Response to Planning application from Hertfordshire County Council (T and CP GDP Order 2015)

District ref: 6/2022/0441/FULL
HCC ref: WH/11546/2022
HCC received: 21 March 2022
Area manager: Matthew Armstrong
Case officer: Steven Knight

12 SOUTHFIELD WELWYN GARDEN CITY AL7 4ST

Retrospective change of use to plant hire (resubmission following refusal of 6/2021/1380/FULL)

SCALE:	DATE:	DRAWN:	CHECKED:	APPROVED:
1:500	12/08/21	SMK	RJM	RJM
JOB NO:	DRAWING NO:	REVISION:		
2104-021	SP02	A

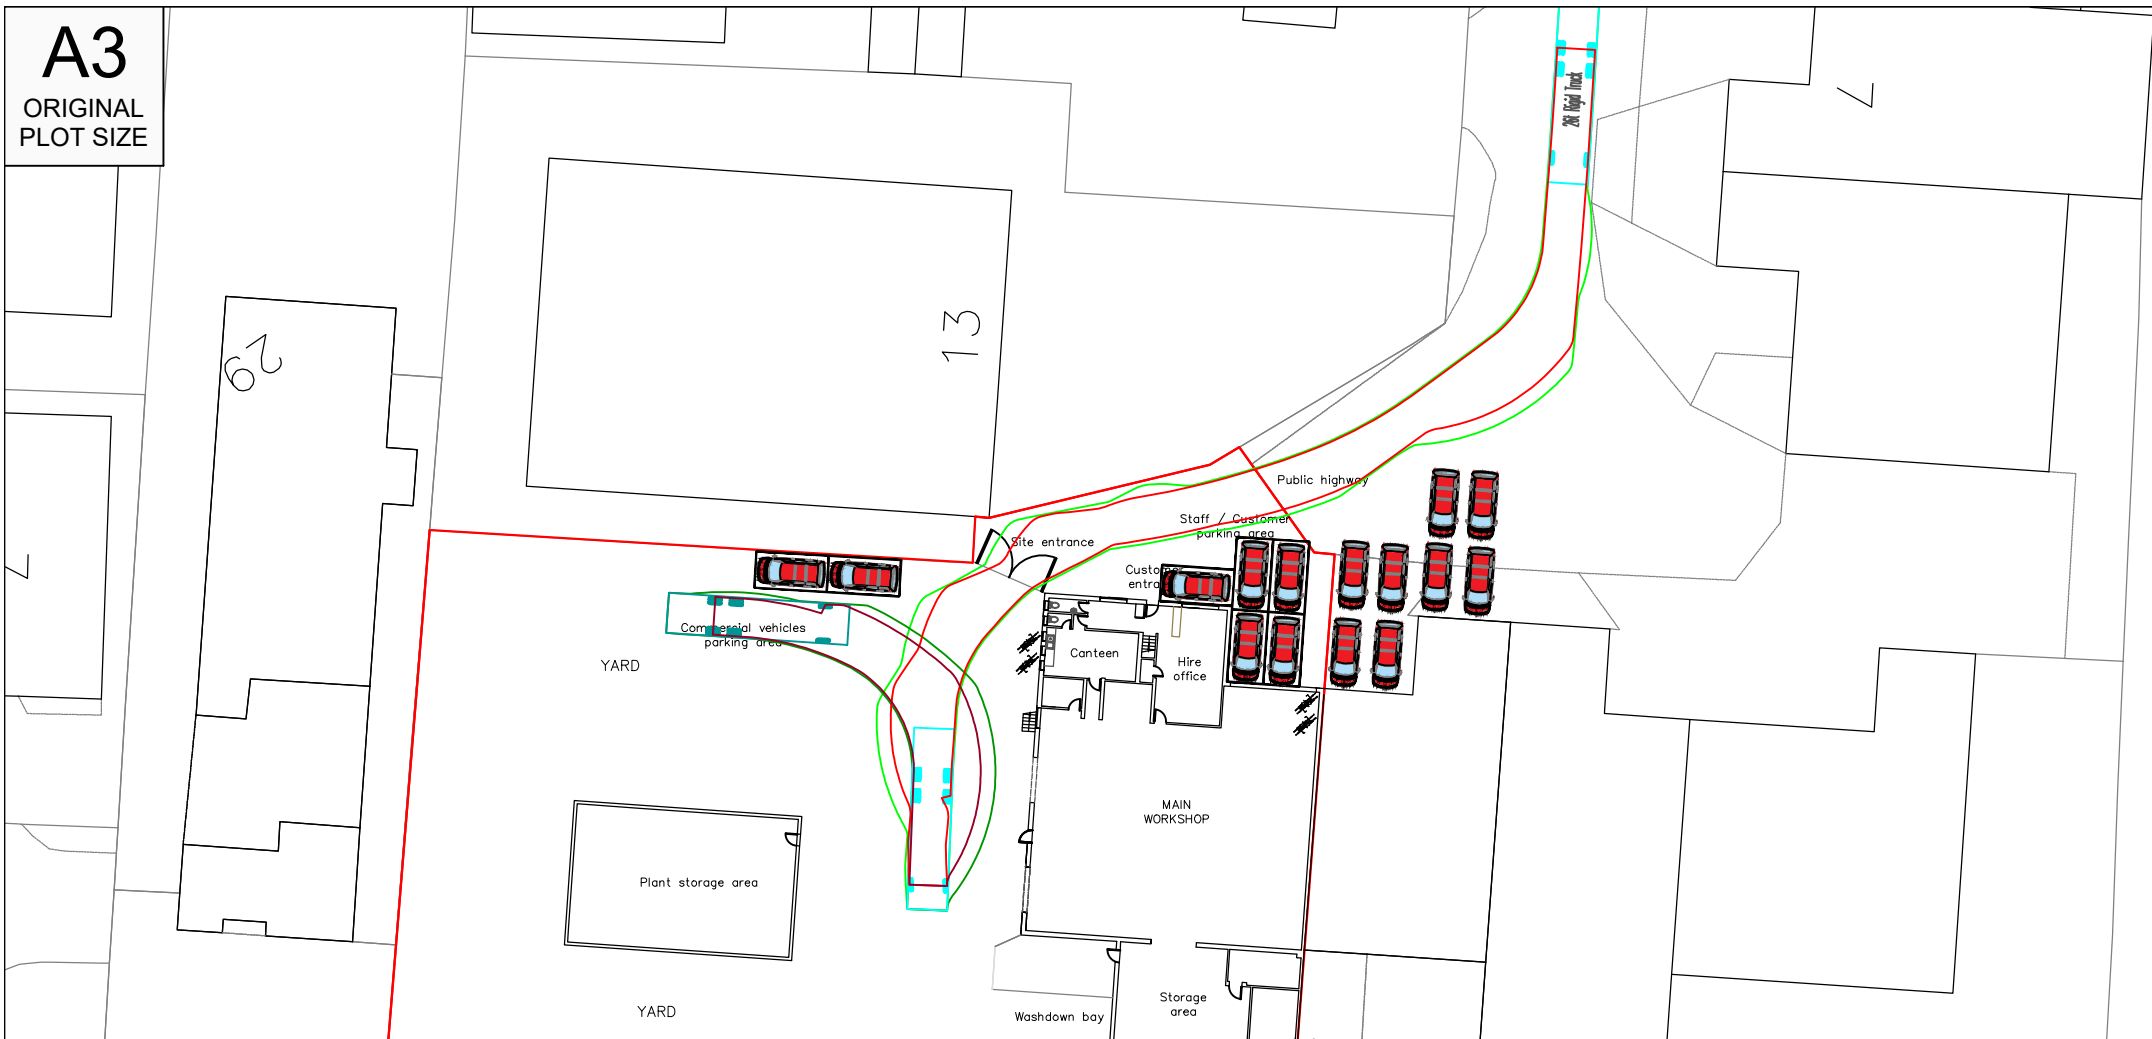
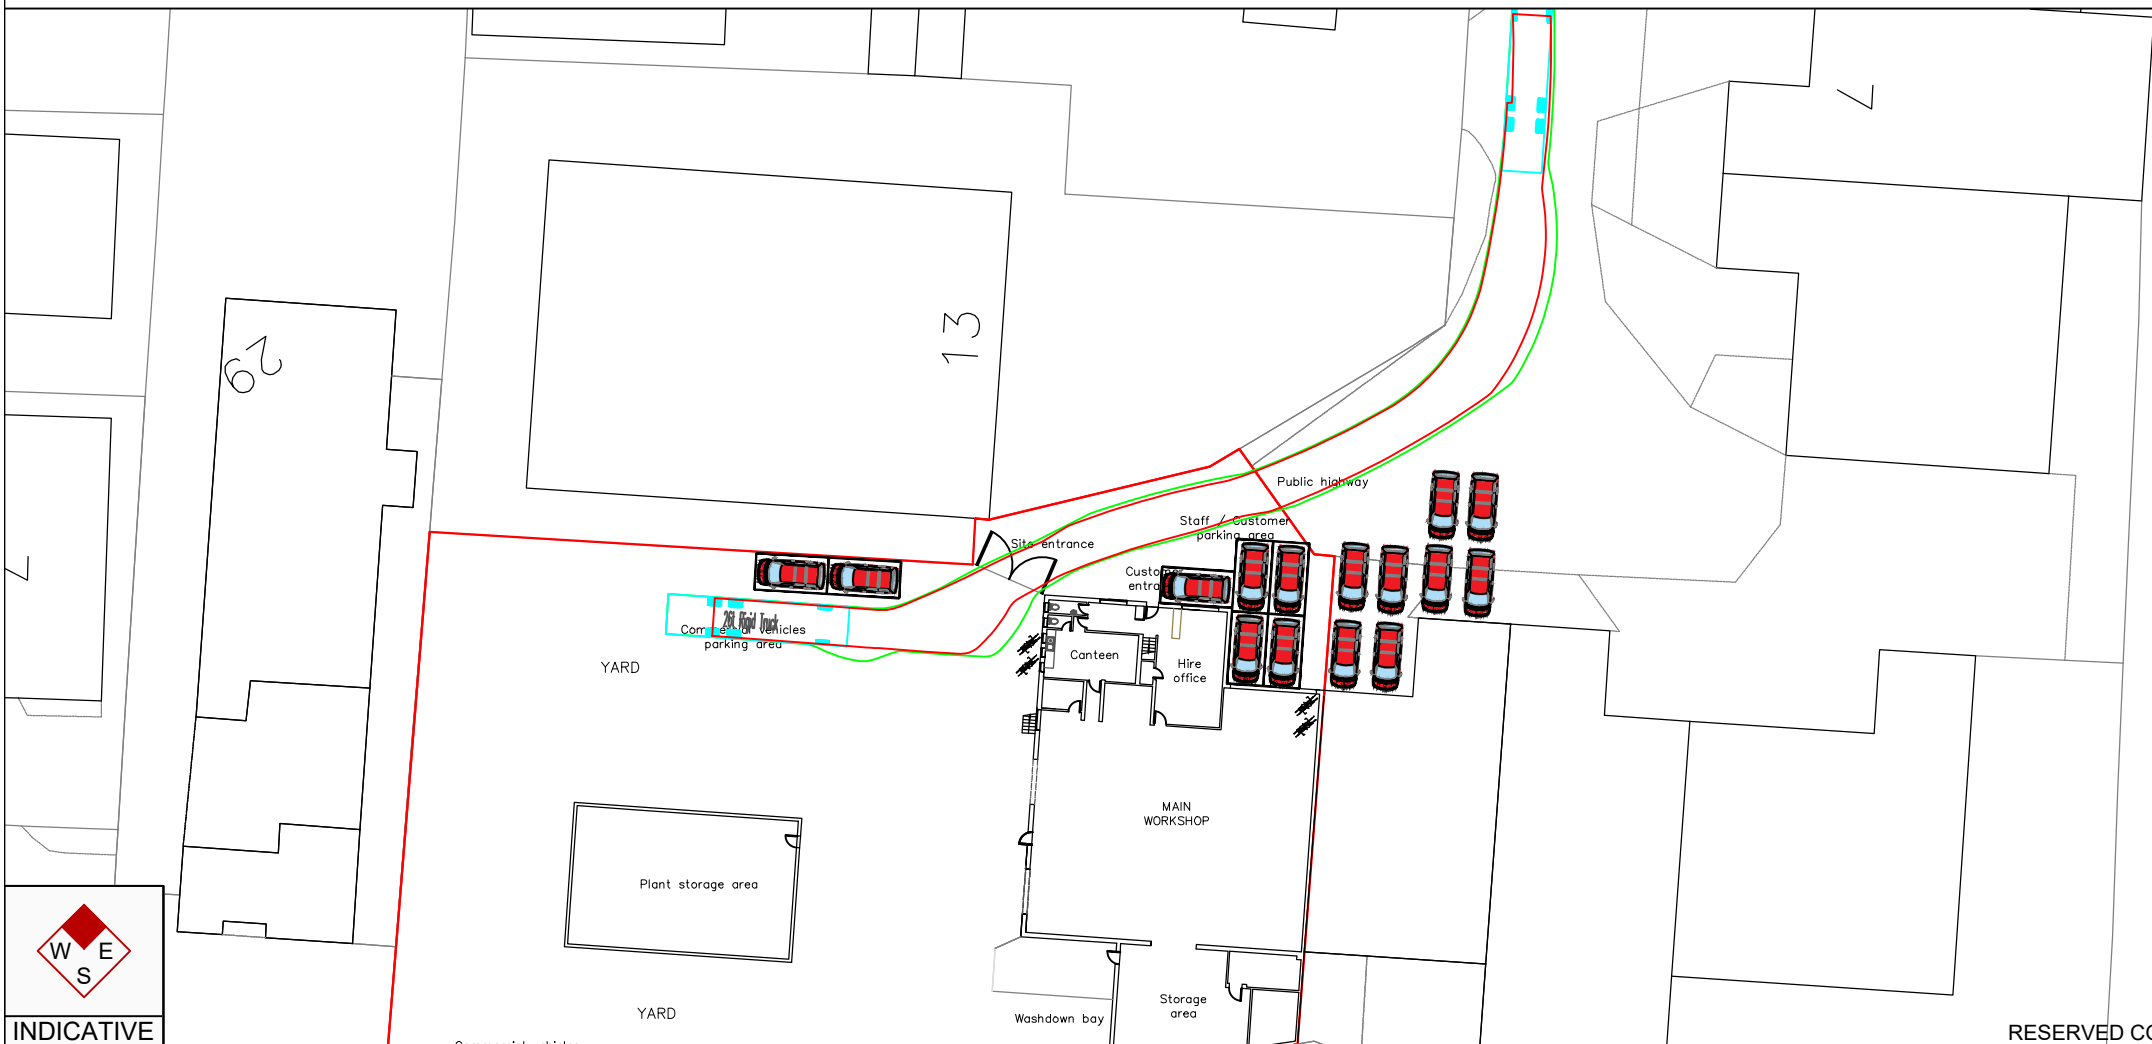
Following first occupation of the hereby permitted retrospective application, the turning area shown by the Swept Path Analysis Drawing No. SP02 Rev. A must be retained and kept clear at all times for loading and unloading purposes of all deliveries, servicing and operational vehicles at the site. Reason: To allow for the efficient delivery of goods (NPPF para 112(d)) and prevent conflict with neighbouring areas, pedestrians, cyclists and vehicles (NPPF para 112 (c)).

The parking spaces within the yard have adequate turning space and will not obstruct the turning movements of large vehicles. However, the parking space outside the hire office will obstruct access for large vehicles entering and leaving the yard based on the swept paths shown on drawing No. SP02 Rev. A. Whilst this should be amended, it is clearly feasible for this be re-oriented to be parallel to the office, as it was on the previous application, or for an additional space to be added within the yard. It is also noted that whilst the provision of 13 parking spaces is required to meet the LPA's maximum parking provision, it isn't a requirement of the highway authority which generally looks to reduce parking provision in order to discourage car use.

The highway authority does not wish to restrict the approval of this application, but recommends the inclusion of the condition stated above to ensure the on-site turning area for large vehicles is retained.
